Our Ref: BR/182/18/HH
Your Ref:

Town & Country Planning Act 1990 (as amended)
Town & country Planning (Development Management Procedure) (England) Order 2015
Application for Planning Permission for Works or Extension to a Dwelling

Development Rear single storey extension & new 2.1m high timber fencing to the north east & north west boundaries.

Location 11A Merrion Avenue Bognor Regis

PROPOSED ELEVATIONS

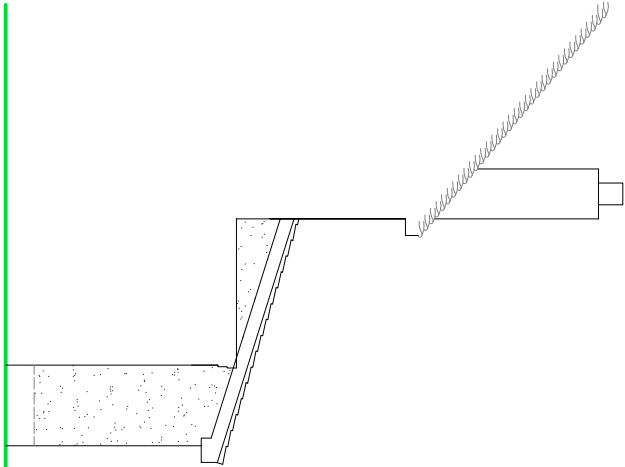
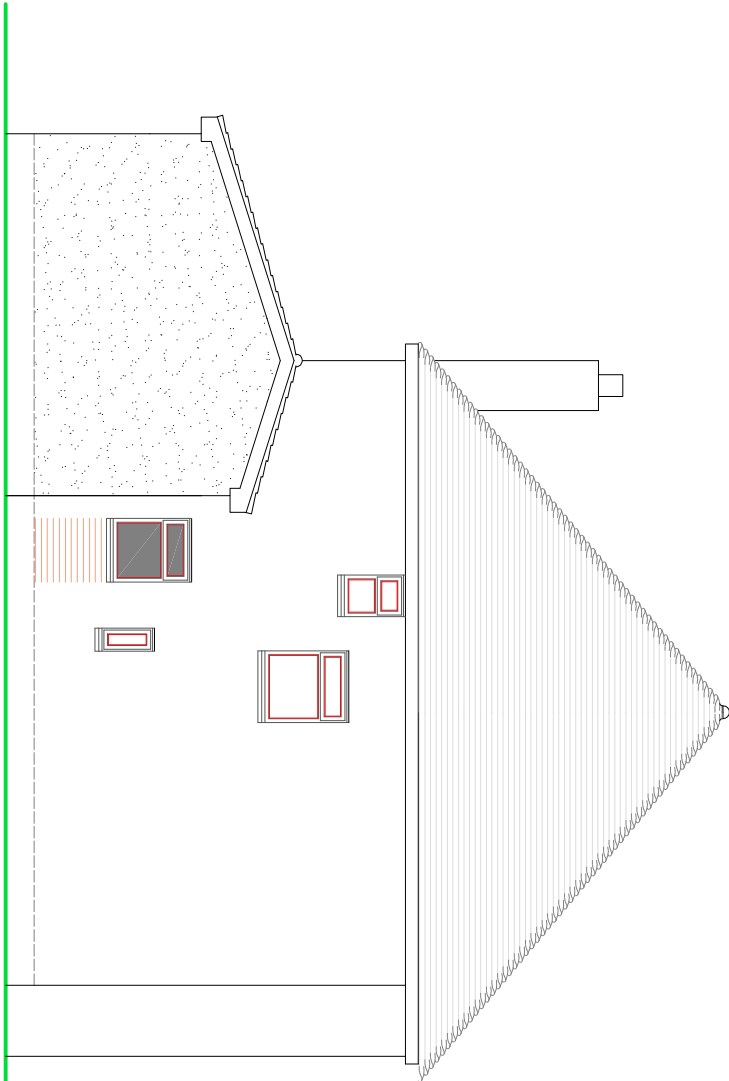
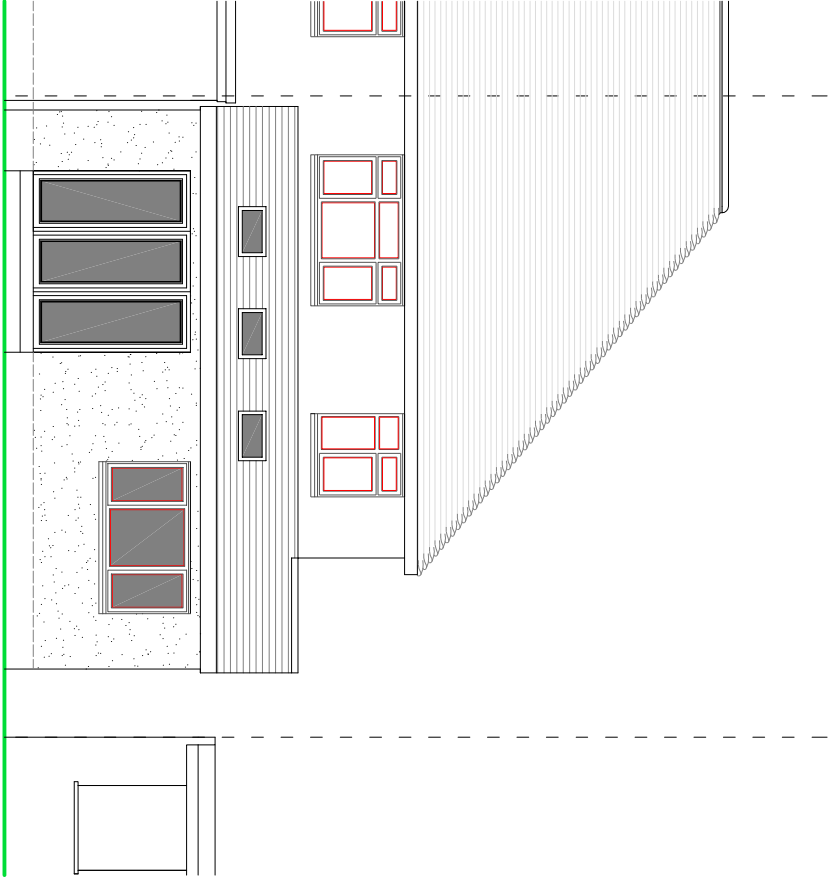
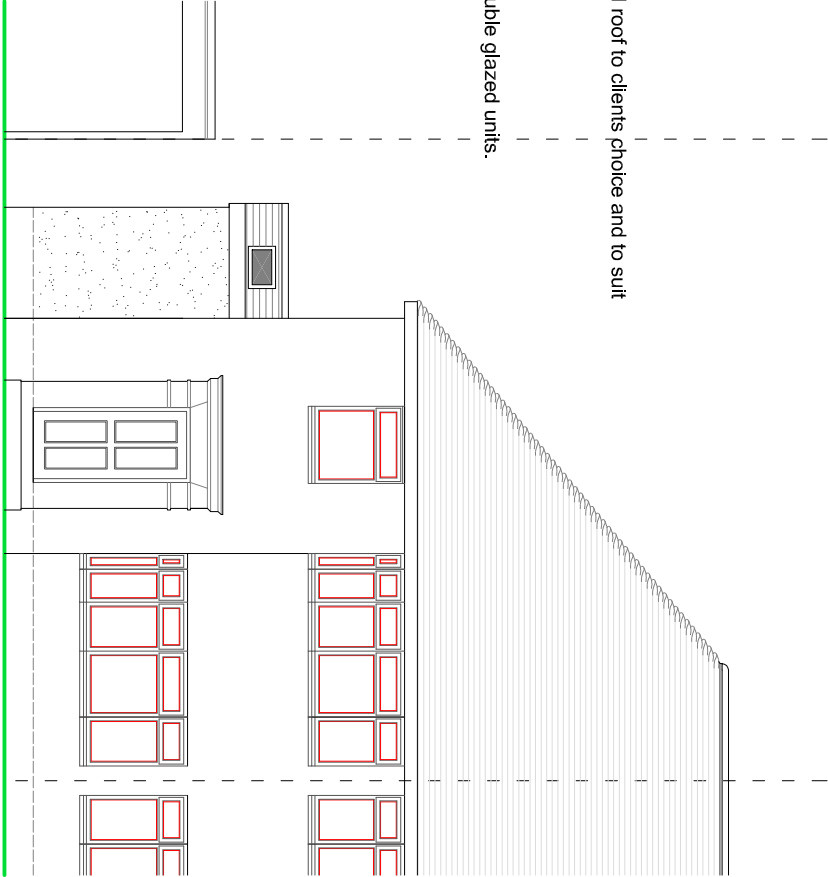
The proposed front and side elevations have been mislabelled. Please amend accordingly.
